Application: 3/2020/0205

Application Site: Spencers Farm, Past Lane Bolton by Bowland

Proposal: Conversion of agricultural building to holiday let

The Granary
Proposed Elevations and Plans
Scale 1:50 @ A1

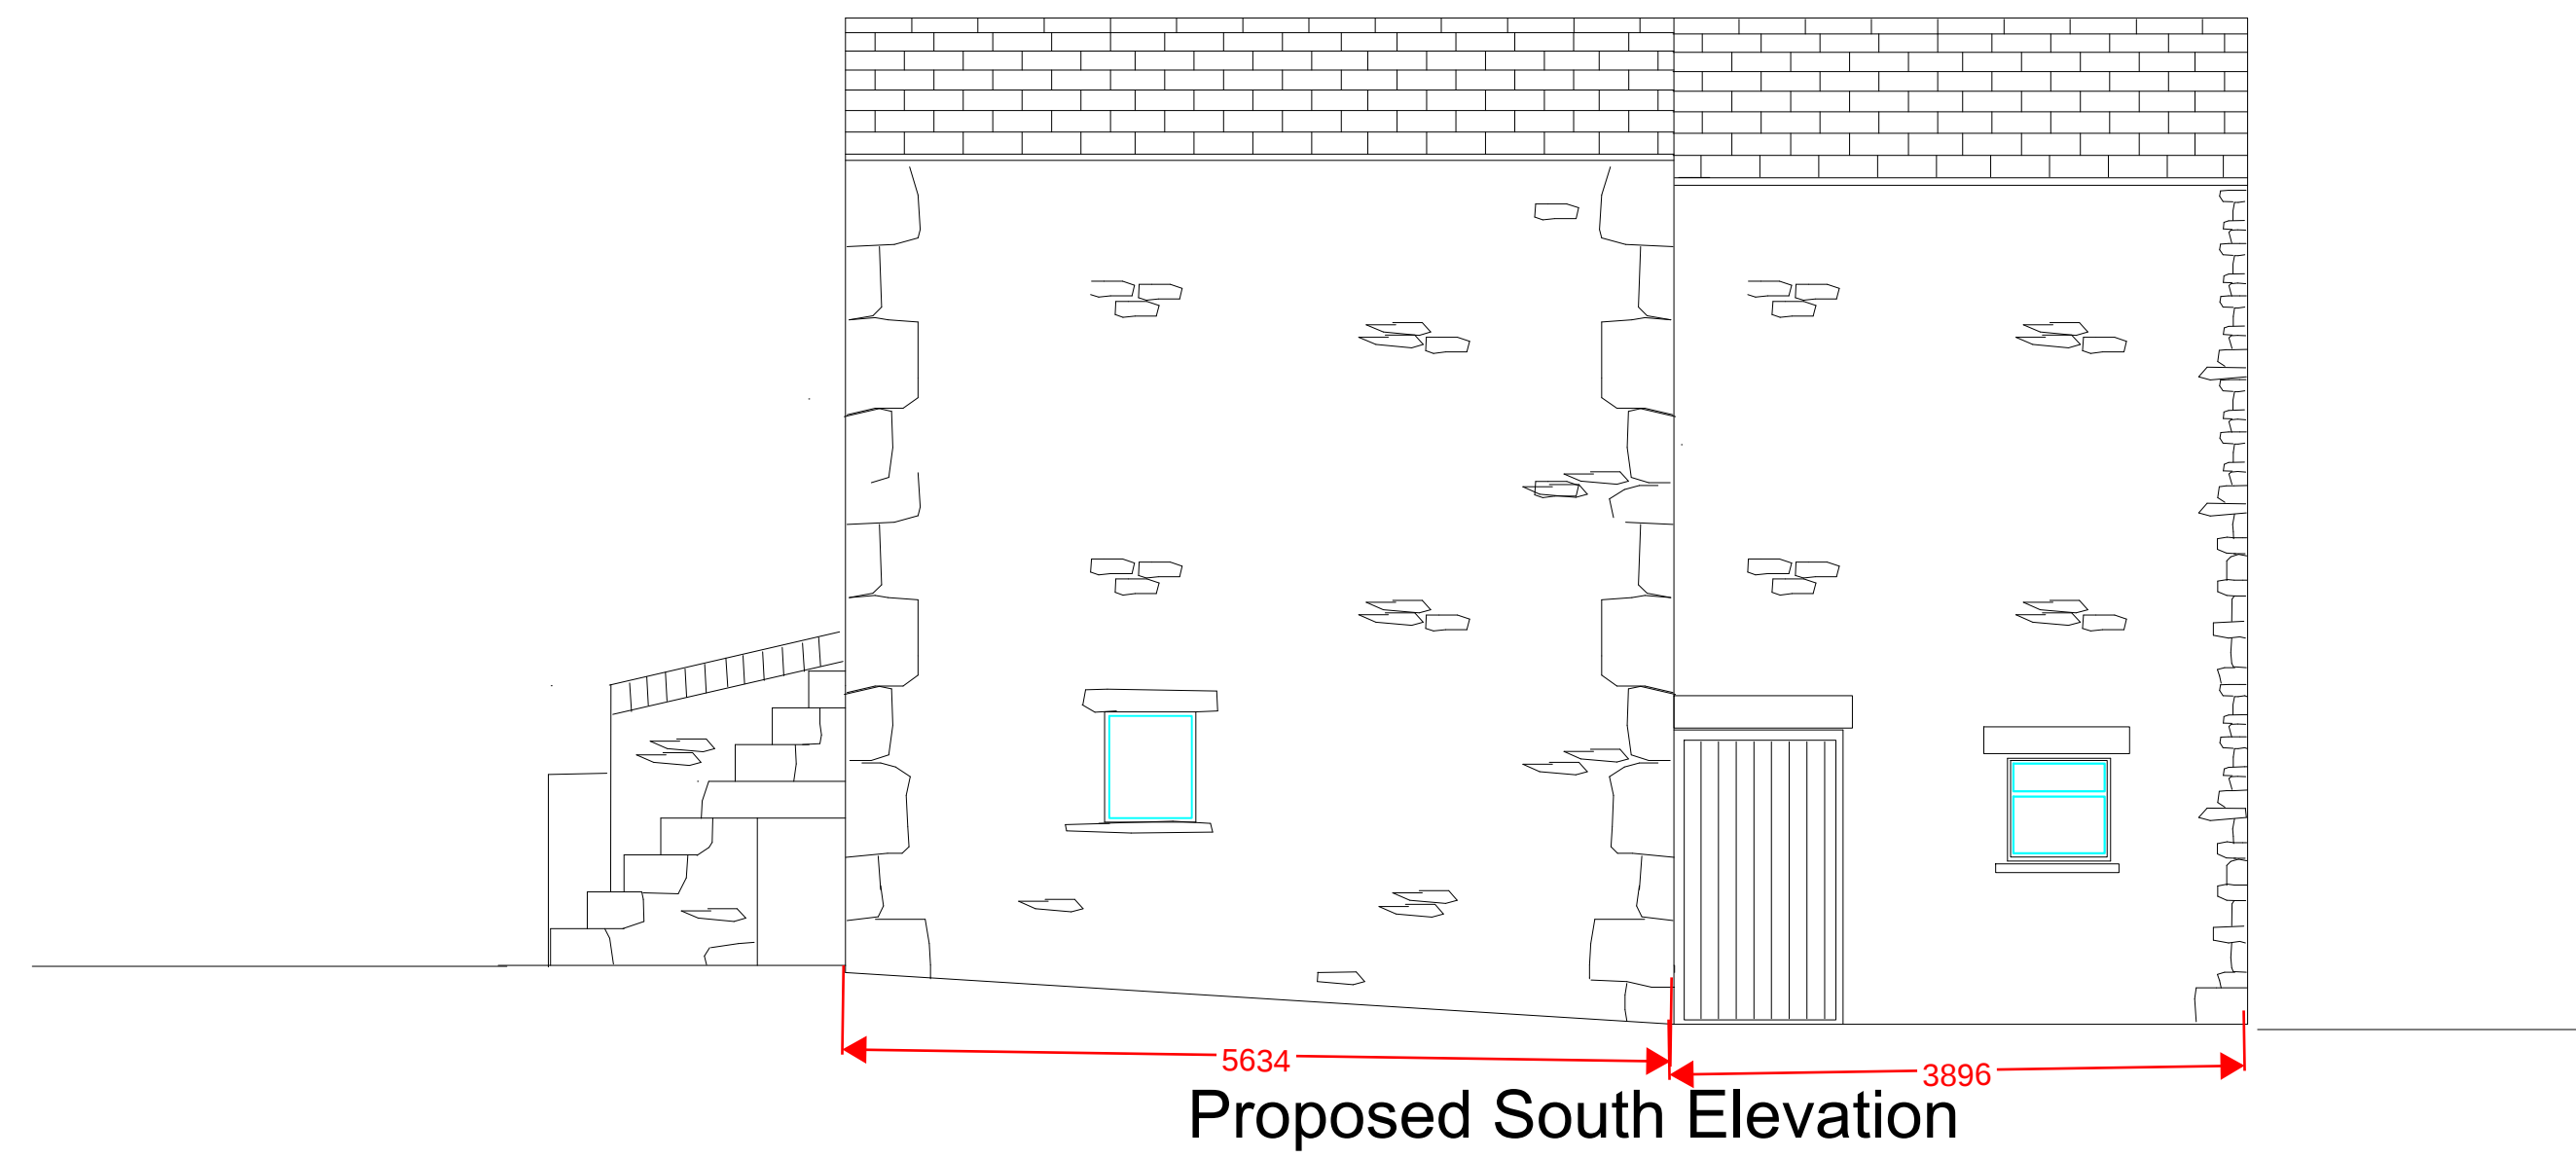
2 the parking of the vehicle shown in the sit layout would appear to be obstructing the vehicular access to the farmhouse. Would it be possible to amend the plan showing the parking facilities for both the farmhouse and the proposed development?
